In reply please quote: 20/05386

10 January 2022

SSD-10436 (MOD 4) – REQUEST FOR ADVICE TO PROPOSED AMENDMENT TO LOT 204 TO THE HORSLEY LOGISTICS PARK AT JOHNSTON CRESCENT

Figure 6 | Proposed Lot 204 Site Plan (new truck entry/exit point identified in red)

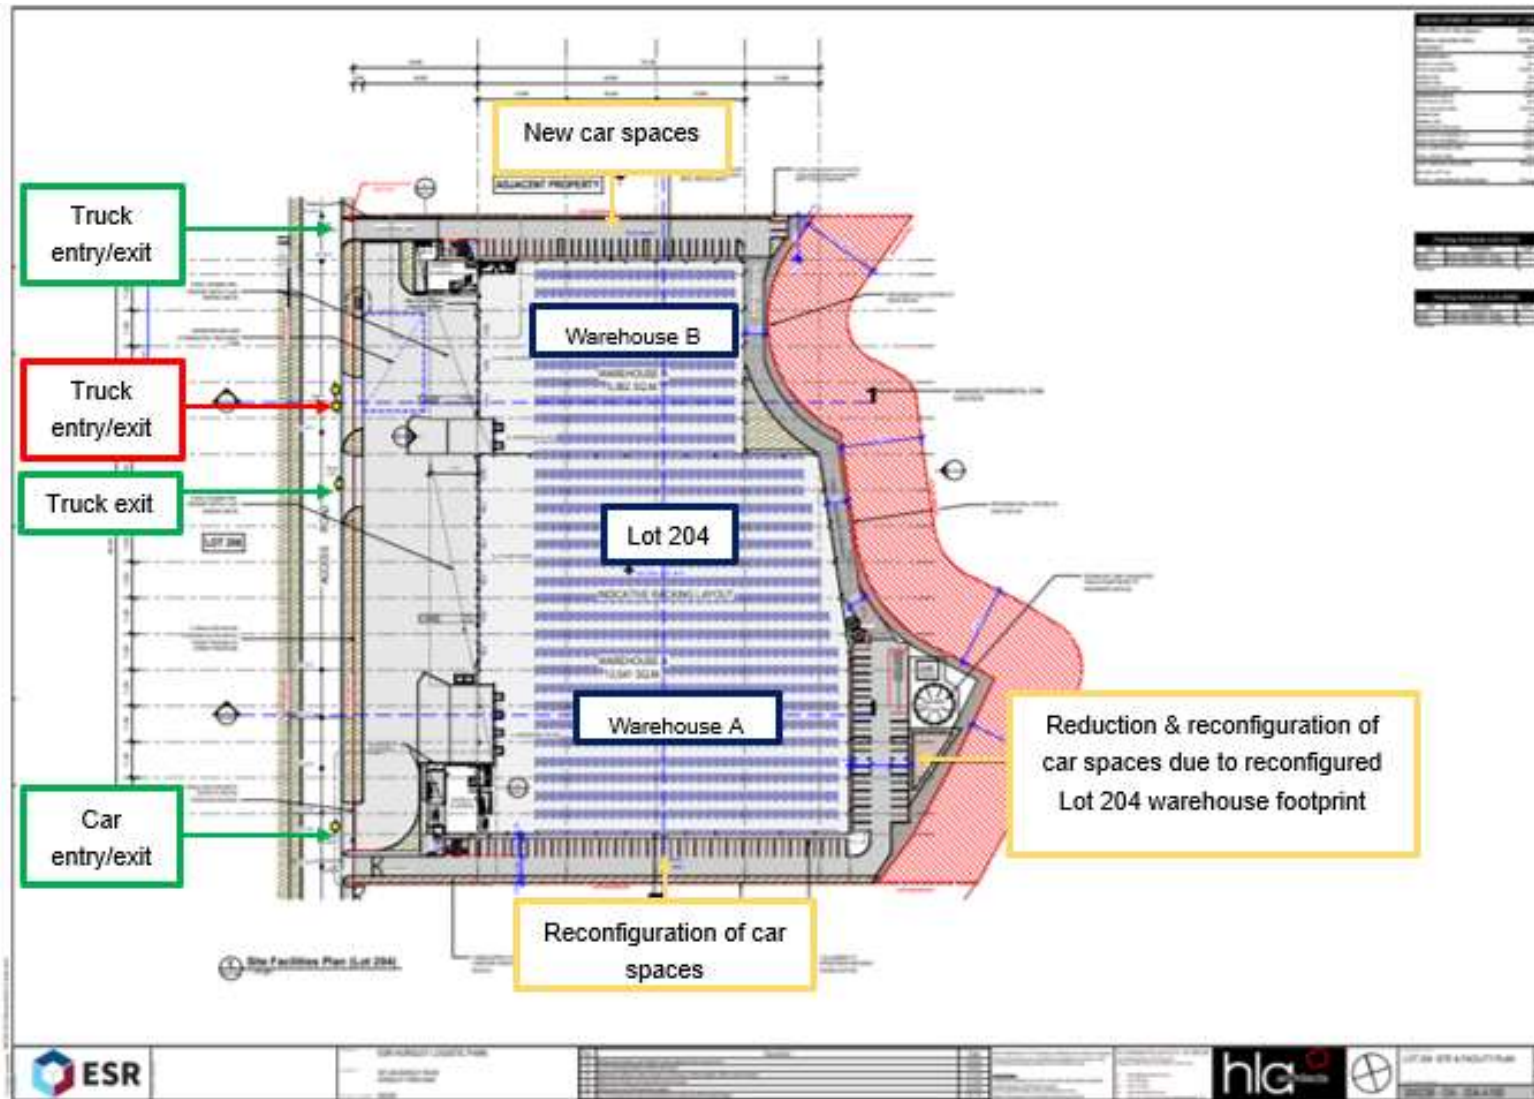
- Swept path diagram (file name AG1839-03-v03.dwg sheet AG06) indicates that 26m B-Double vehicle turn right into the site via the truck entry/exit driveway. It is anticipated that heavy vehicles would generally head south on Johnston Crescent to turn left into the site rather than making the right turn into the site. Clarification is required about this right-turn movement which is required to use the opposing traffic lane in order to turn into the driveway. Based on the applicant's swept path diagram (AG1839-03-v03.dwg sheet AG07), there is insufficient width at the entry/exit driveway to accommodate two-way simultaneous traffic movements i.e. left turn movement undertaken by a southbound 26m B-Double vehicle into the site and another vehicle waiting to exit the site. Concern is raised regarding 26m B-Double vehicle turning left from Johnston Crescent into the site via the entry/exit driveway which will conflict with other users;

Figure 8 | Swept path diagram AG11 – 12.5 m HRV emergency vehicle

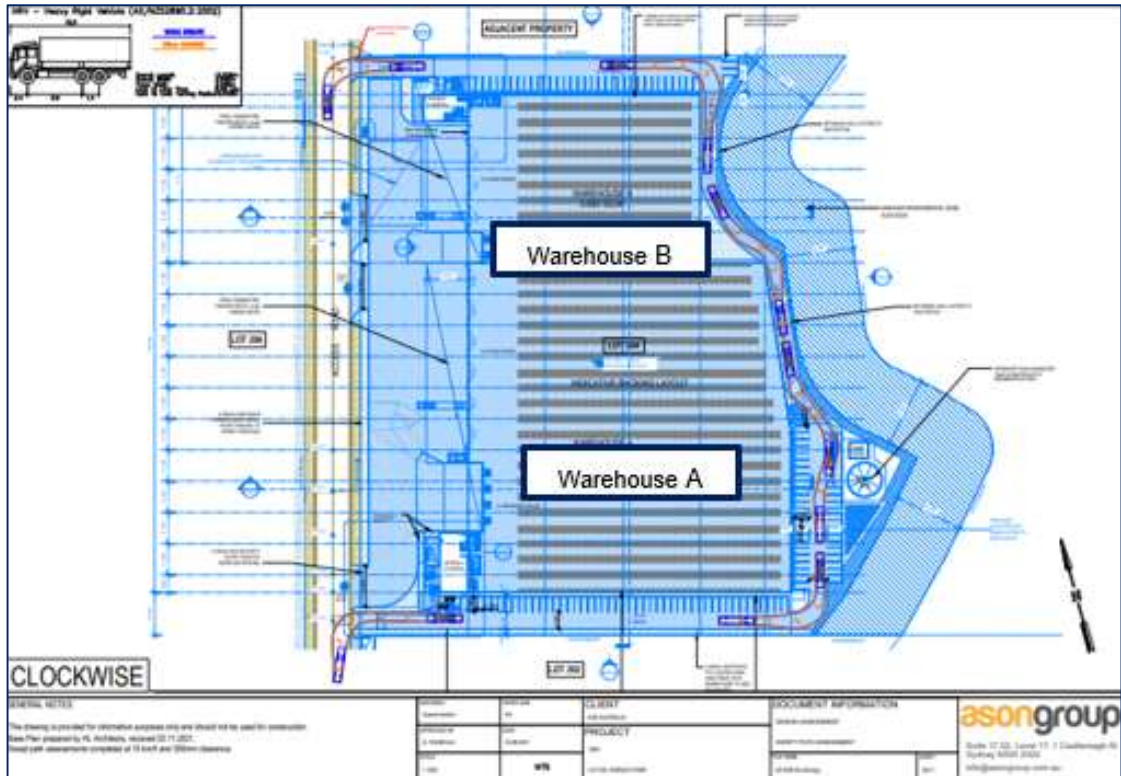
- Swept path diagram (file name AG1839-03-v03.dwg sheet AG11) shows that heavy rigid vehicles entering the southernmost and northernmost driveways of the site will potentially conflict with other road users. The width of the driveways is not sufficient to cater for the simultaneous movements of a HRV and another vehicle. Additional information shall be submitted to Council to address this concern; and
